**Application No: MP07_0158
MOD 3**

**Exhibition of Modification
Request for the University of
Sydney Abercrombie Precinct
Redevelopment**

Date: 10 November 2013

Name: JOHN GAIN

Ground Floor Plan
1:200@A1
11.10.13
4001_DA02-D

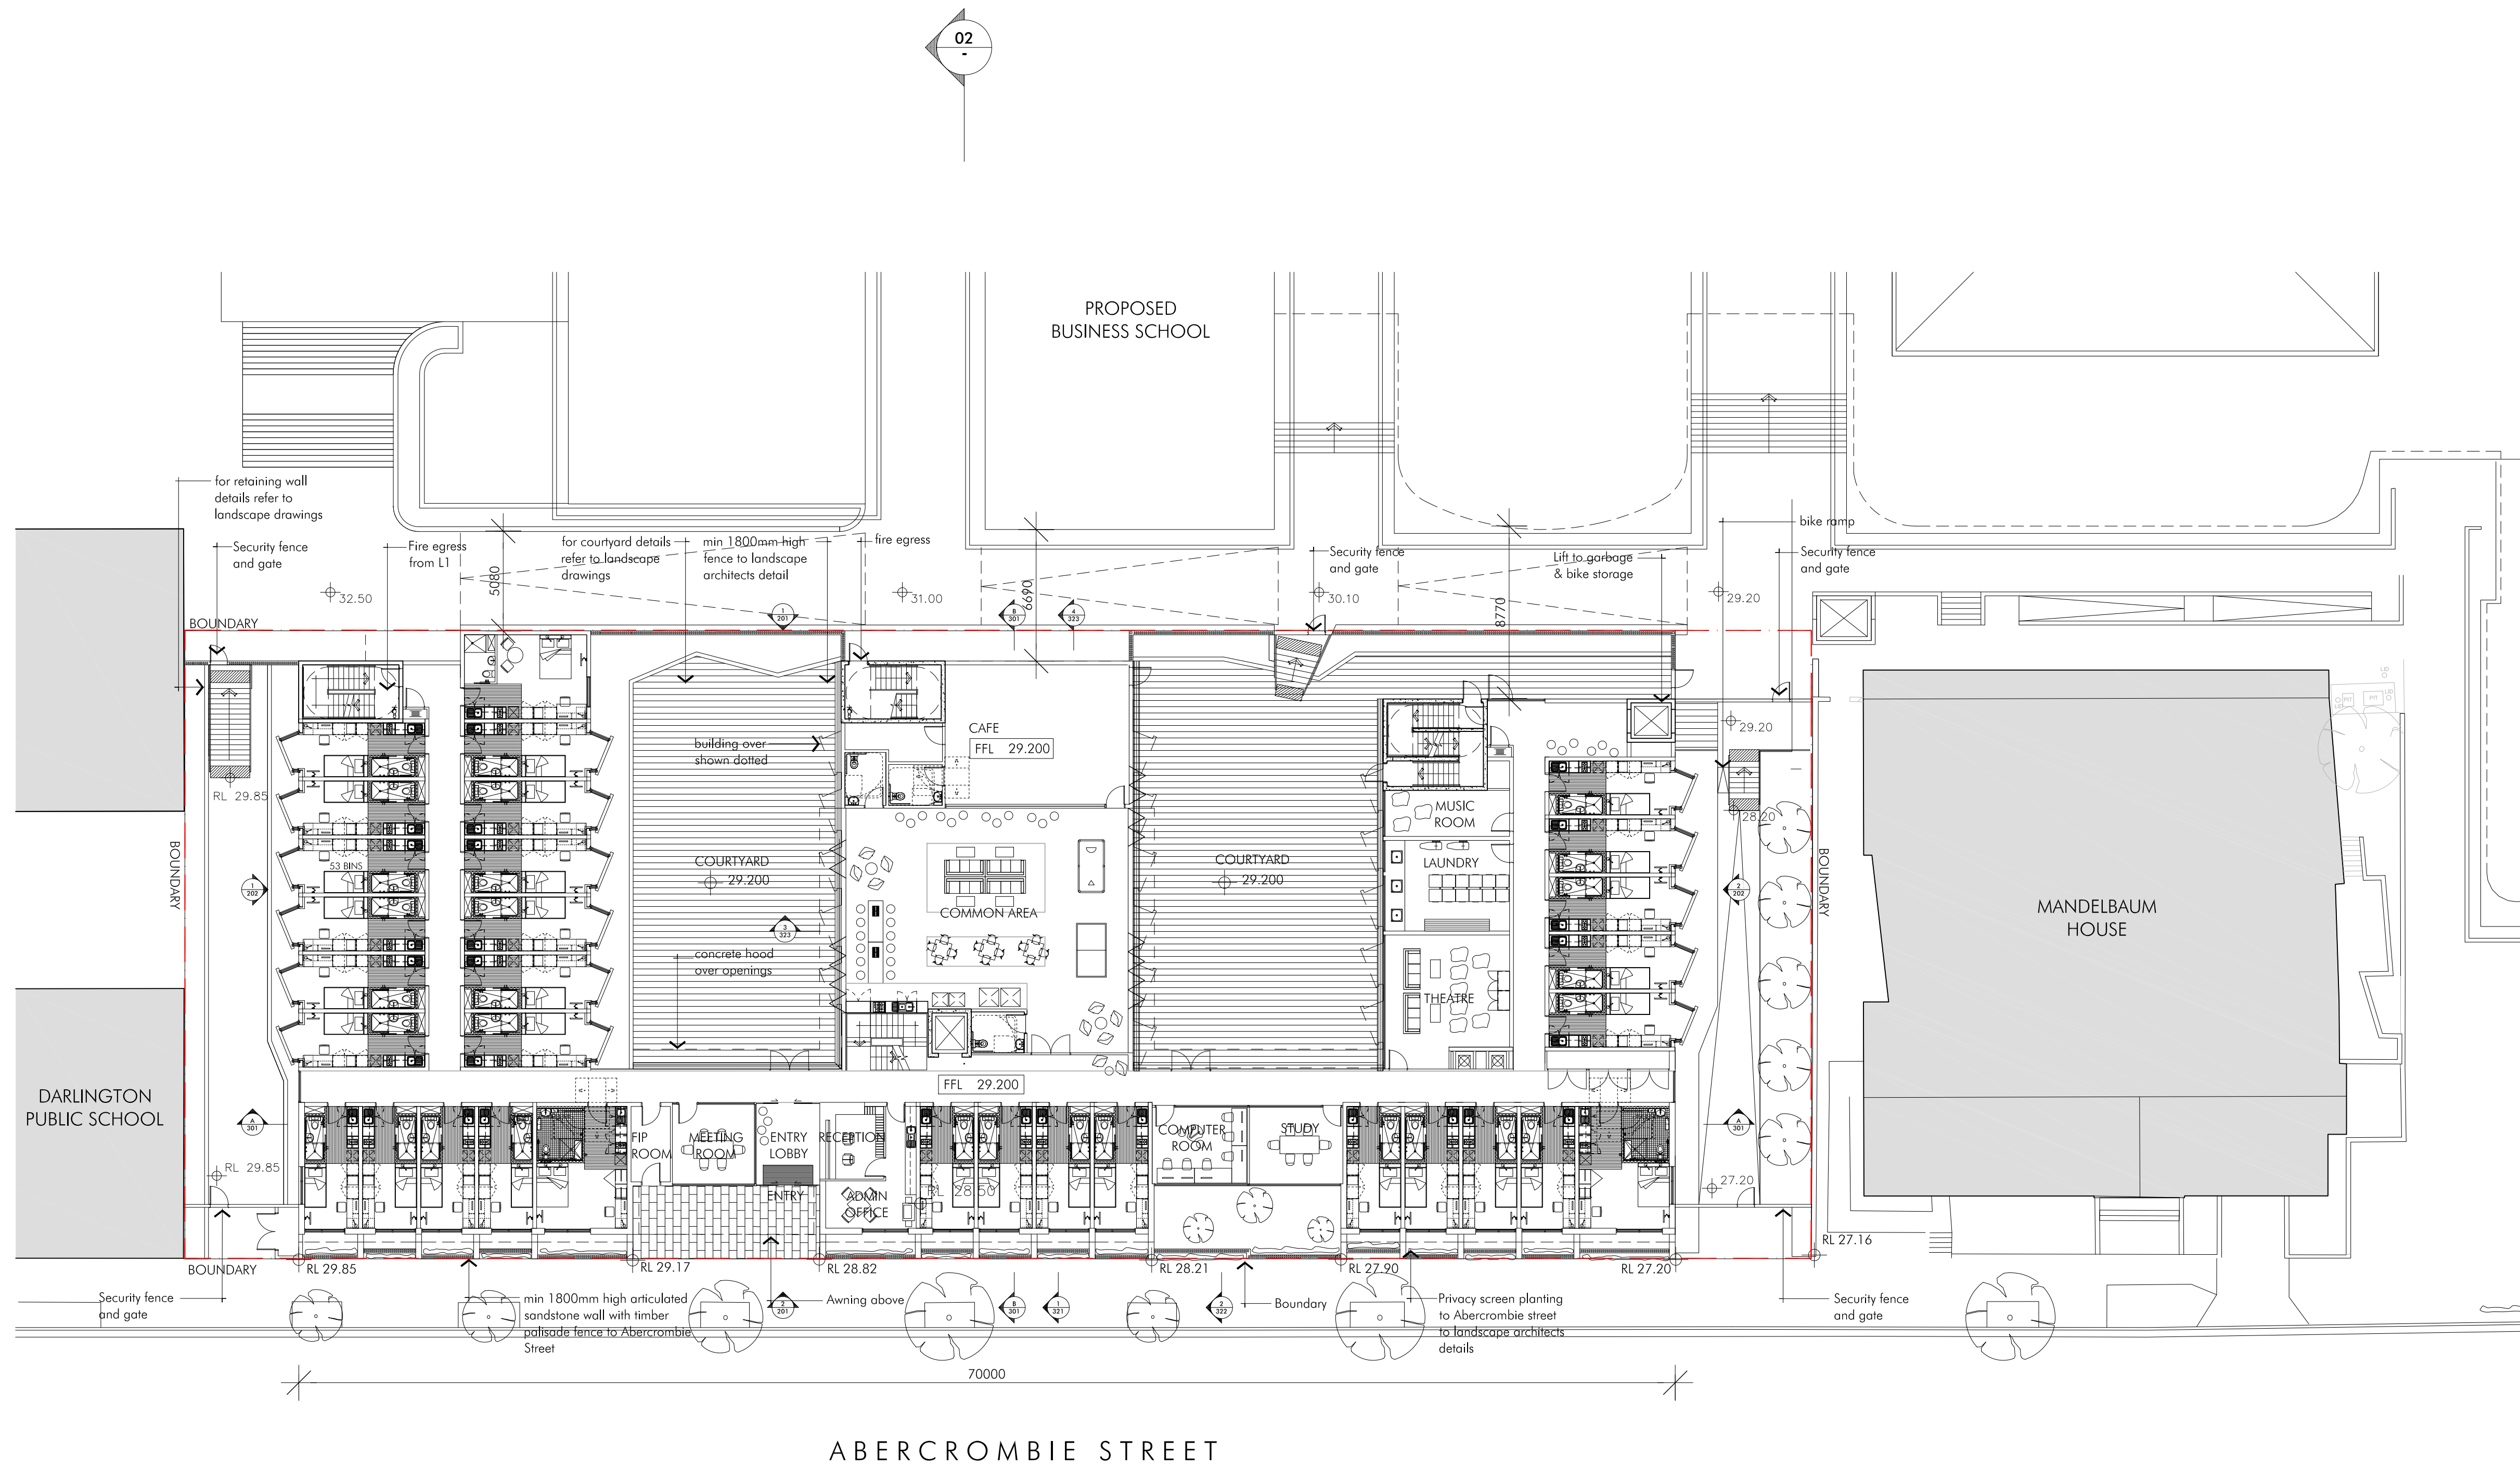
We believe that the Student Accommodation should also be set back from the front boundary by 2 metres and built in line with Mandelbaum House. Once again there should be no exceptions for the University owned building and it should be made to comply as other buildings have along Abercrombie Street. It should also be contained within the same footprint as those buildings being demolished to make way for it.

The latest plans for the Student Accommodation, whilst showing the front of the building abutting the boundary on Abercrombie Street, also show an increase in floor area at the back towards the Business School.

The whole building should be moved back to align with Mandelbaum House as it was originally planned and presented to the residents - see above pictures. There should be no increase in floor area at the back and the number of students living in the facility should be restricted to the originally approved 188 or to an even lesser number. The number of students should not be increased to 200 as is now proposed.

Access pathways are proposed for either side of the new Student Accommodation running from Abercrombie Street into the APD at the back of the Student Accommodation.

The areas at either side of the proposed Student Accommodation should be kept as green areas. The provision of heavily landscaped buffers at each end of the Student Accommodation will discourage students and other groups from congregating at all hours bringing noise and disruption to residents living nearby as well as those living within.

The plans show a music room facing into Abercrombie Street. This room and any others that would have loud noise and are places where students will gather in numbers must be sound proofed protect the amenity of residents.

02 ELEVATION SOUTH (ABERCROMBIE STREET)
SCALE 1:200

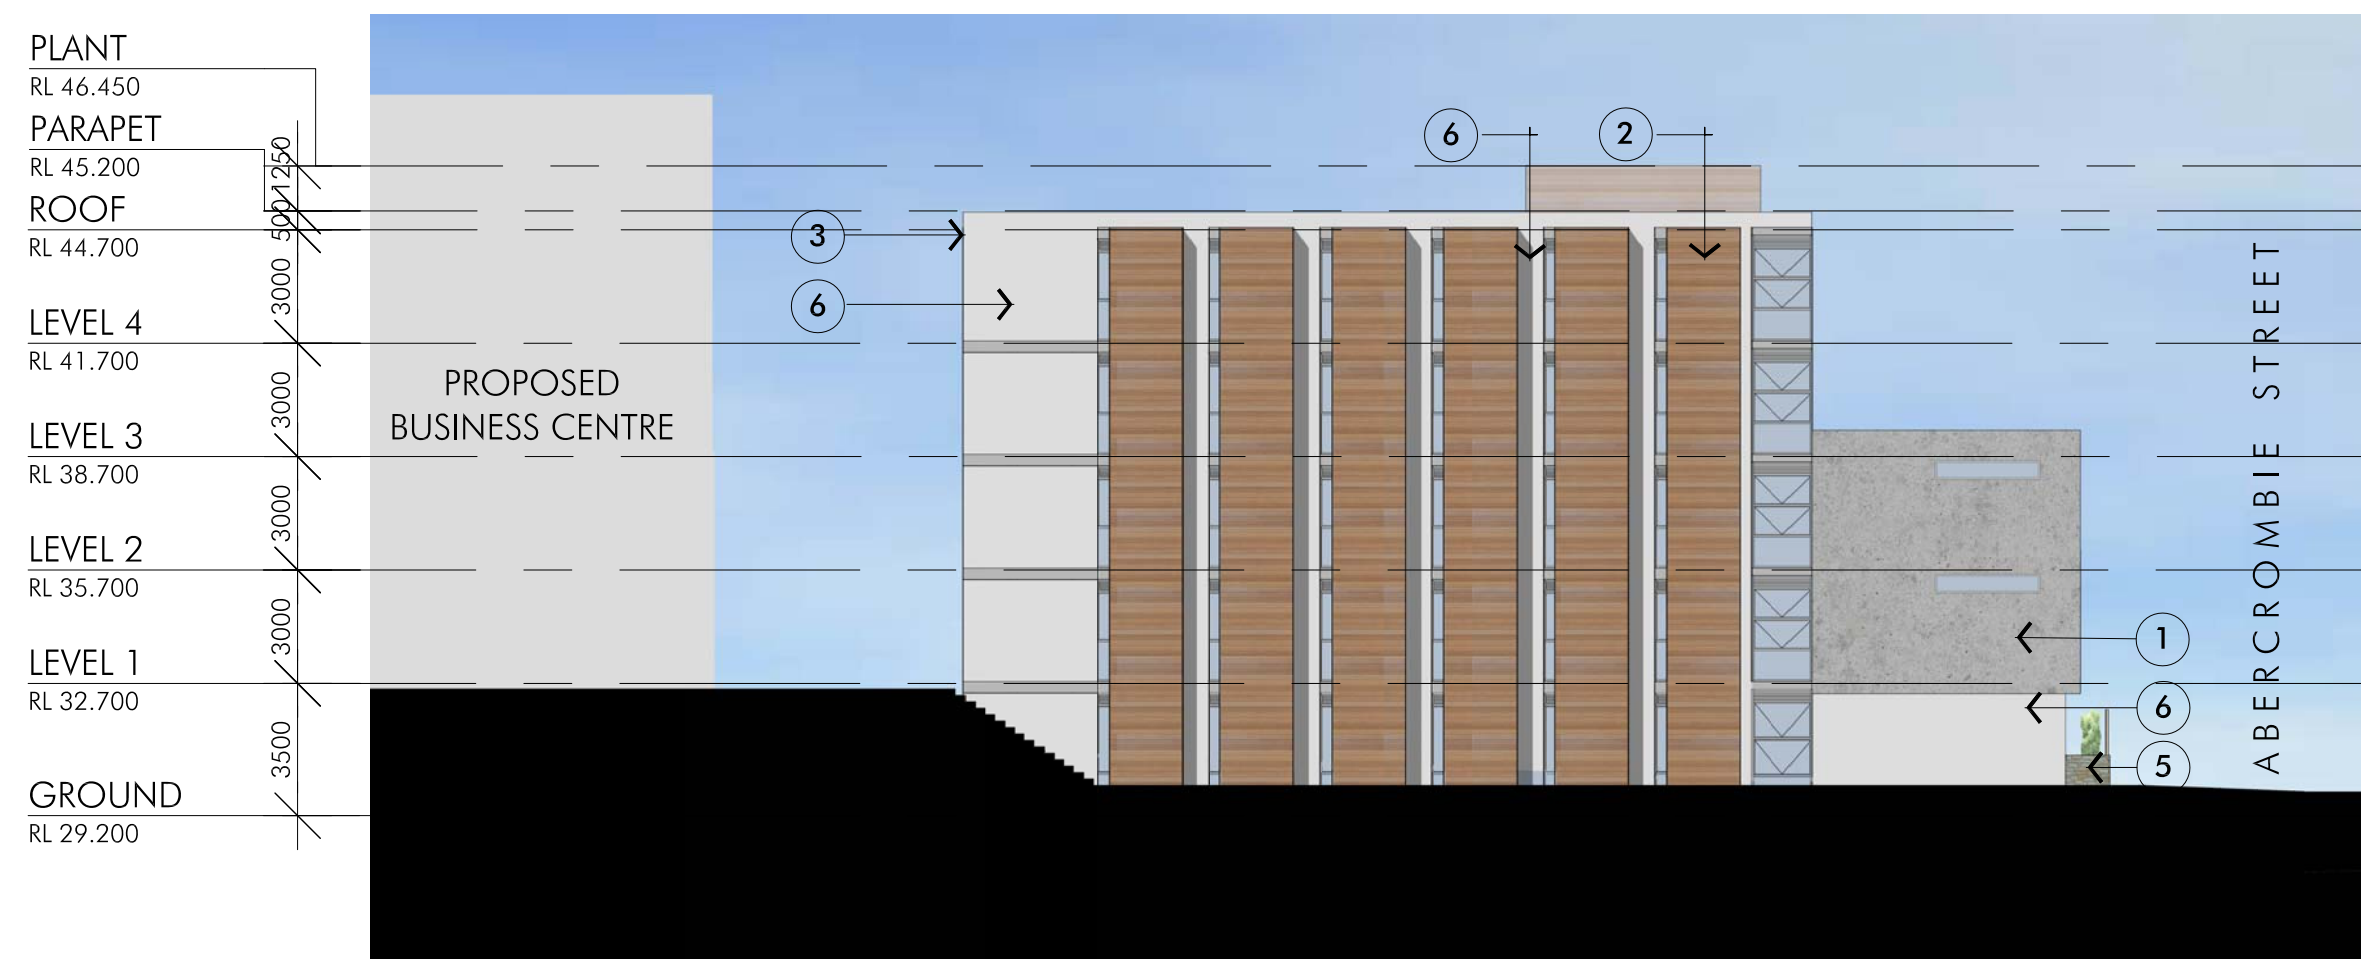
- The University's own elevation below clearly shows that Darlington Public School, outlined in red on the left of the picture, is a 2 storey building which sits well below the 5 storey Student Accommodation.
- The red line at the top of Mandelbaum House on the right of the Student Accommodation is actually the height of its pitched roof.

Many objections made to the original plans for the APD Business School and Student Accommodation buildings were on the basis of their height, bulk and scale, especially as they are proposed to stand much higher than Mandelbaum House to the east and Darlington Public School to the west, dwarfing both of them.

The scale of the proposed Student Housing building along Abercrombie Street is up to five storeys, which is out of character with the prevailing height and scale of the 2-3 storey Victorian terraces on the southern side of Abercrombie Street and a number of other traditional buildings mainly located at the intersection between Abercrombie Street and Codrington Street.
